**WELWYN HATFIELD BOROUGH COUNCIL
EXECUTIVE DIRECTOR - PLANNING, PUBLIC PROTECTION AND GOVERNANCE**

DELEGATED APPLICATION

Application No: 6/2022/1657/HOUSE
Location: 159 Parkway Welwyn Garden City AL8 6JA
Proposal: Installation of three rear rooflights to facilitate the conversion of the loft to habitable space
Officer: Ms Emily Stainer

7 Proposed Rear Elevation
1 : 100

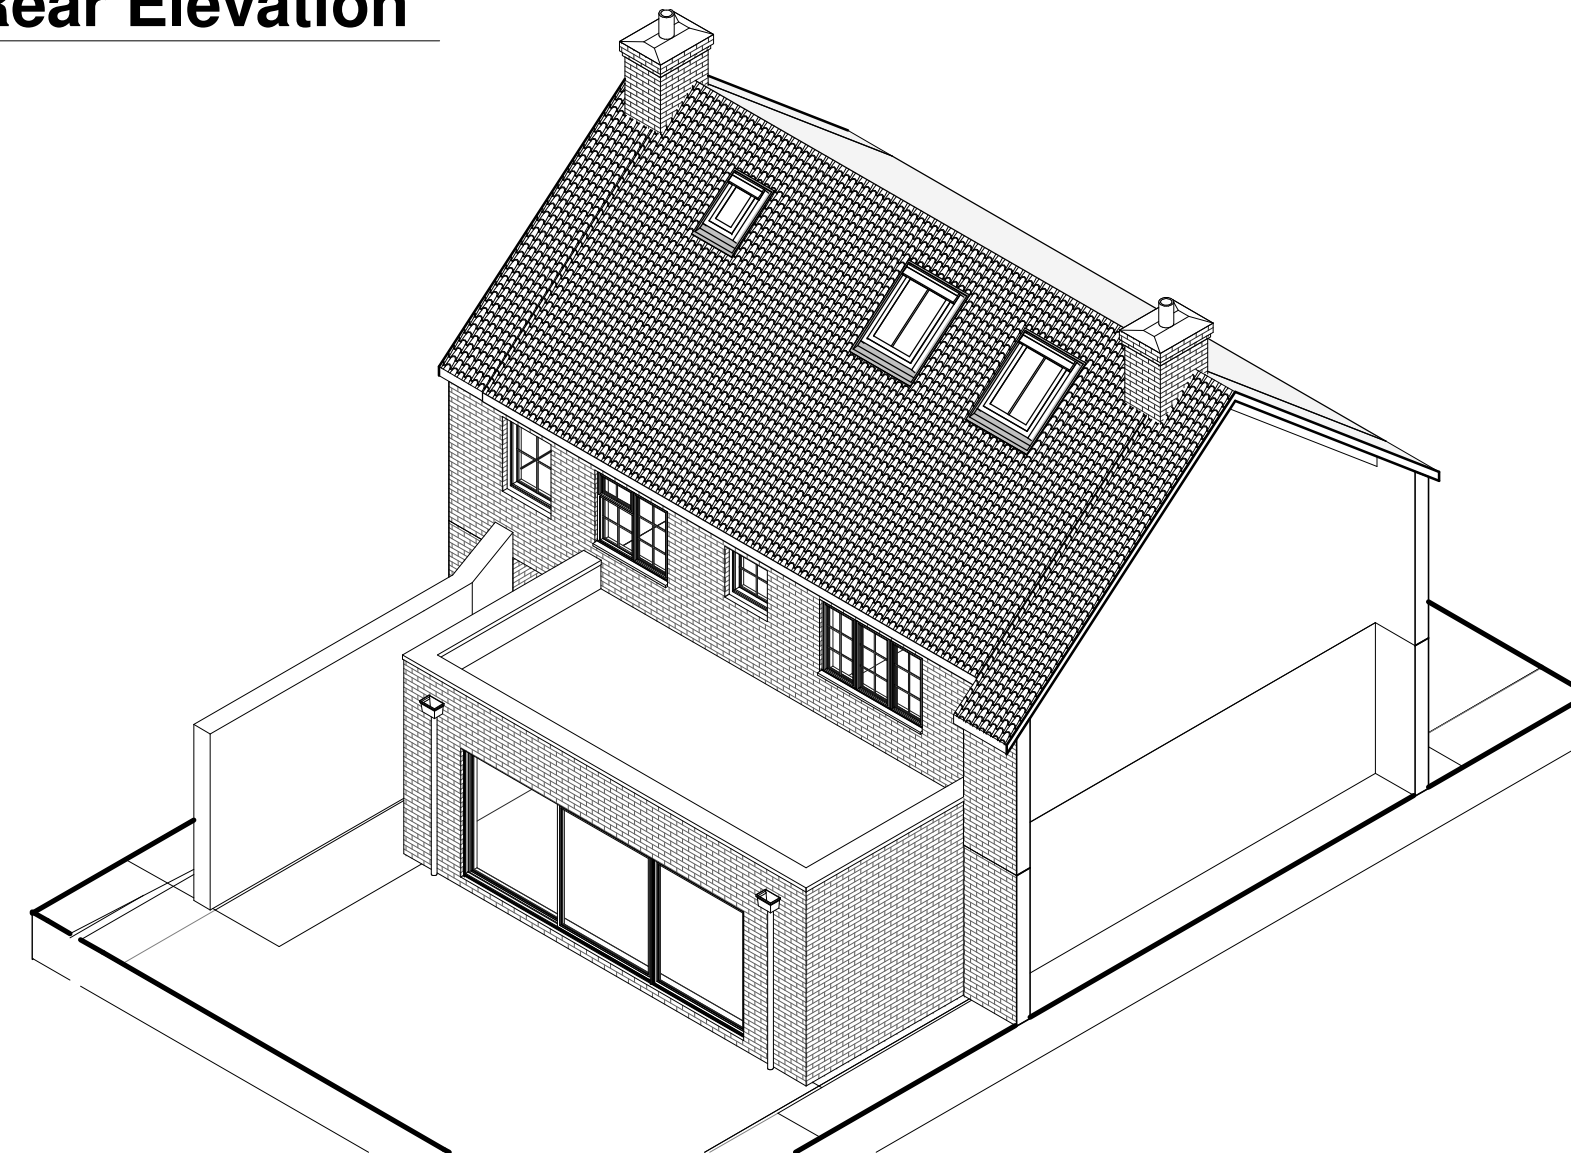
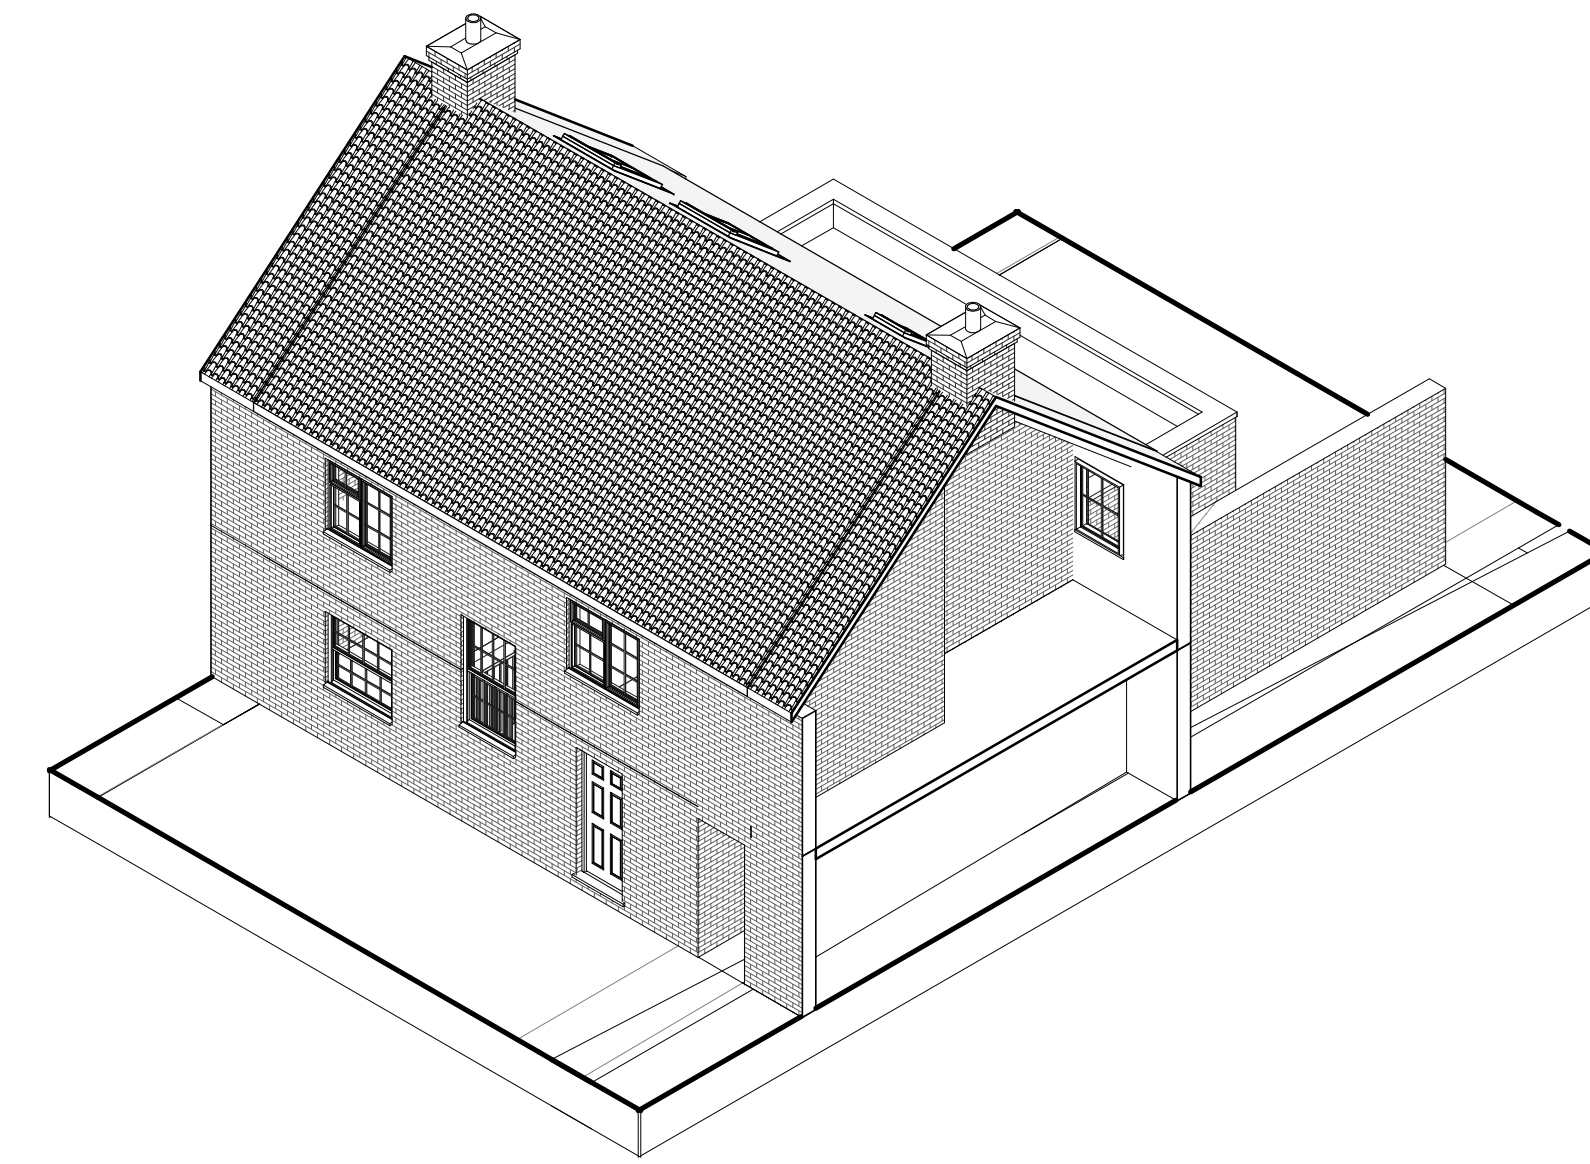
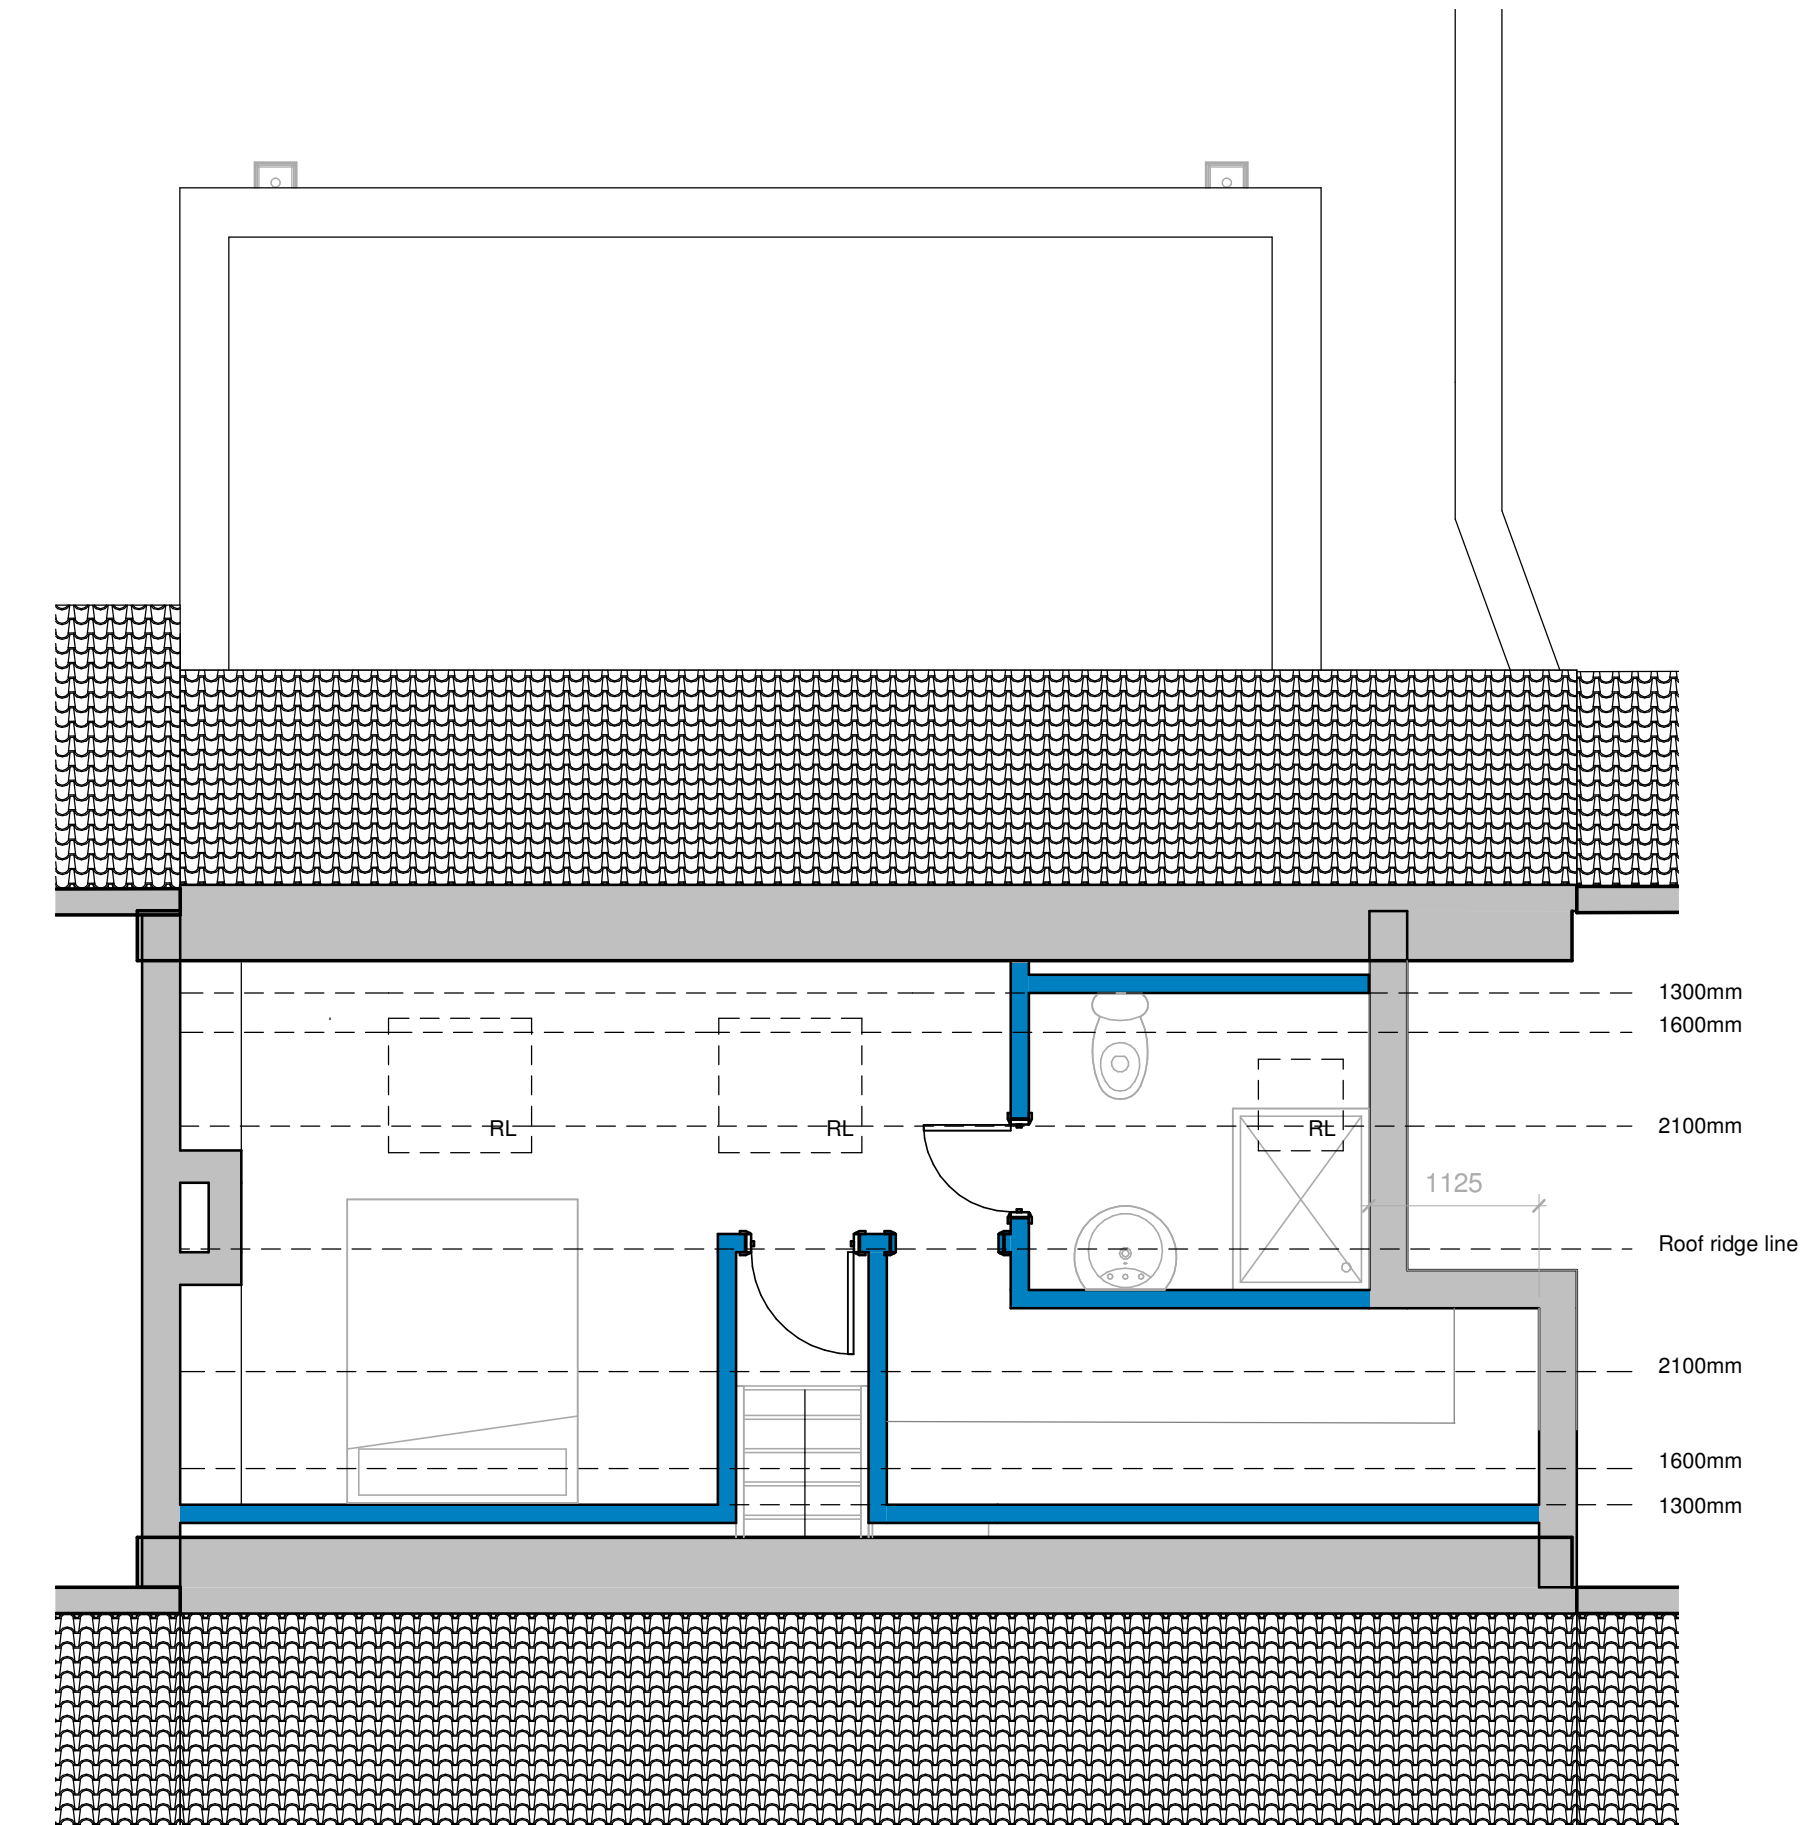
This application follows the refusal of application 6/2022/0529/HOUSE which was an application for the construction of two rear dormers to facilitate the conversion of the loft to habitable space. The reason for refusal was because the proposed dormers would have failed to preserve or enhance the character and appearance of the Garden City and would harm the significance of the Conservation Area. The proposal which was originally applied for under this latest application also included dormers. However, it was amended at the request of the applicant to 3 rear rooflights and no dormers.

The amended design would ensure the front roofslope remains uninterrupted and the impact on the rear roofslope would be minimal. The Council's Conservation Officer has also commented, noting that no objections are raised as the character and appearance of the Conservation Area will be preserved and its significance is not harmed, in accordance with Section 72 of the Planning (Listed Buildings and Conservation Areas) Act 1990 and Section 16 of the NPPF. This is subject to a condition being imposed which requires the submission and approval of further details for the rooflights. On the above basis the proposed development can be approved.

1. No external development above ground level shall take place until additional detailed drawings of the new rooflights have been submitted to and approved in writing by the Local Planning Authority. The drawings must detail the rooflights within the existing building in section and elevation at an appropriate scale and provide details of any materials proposed. The development shall be implemented
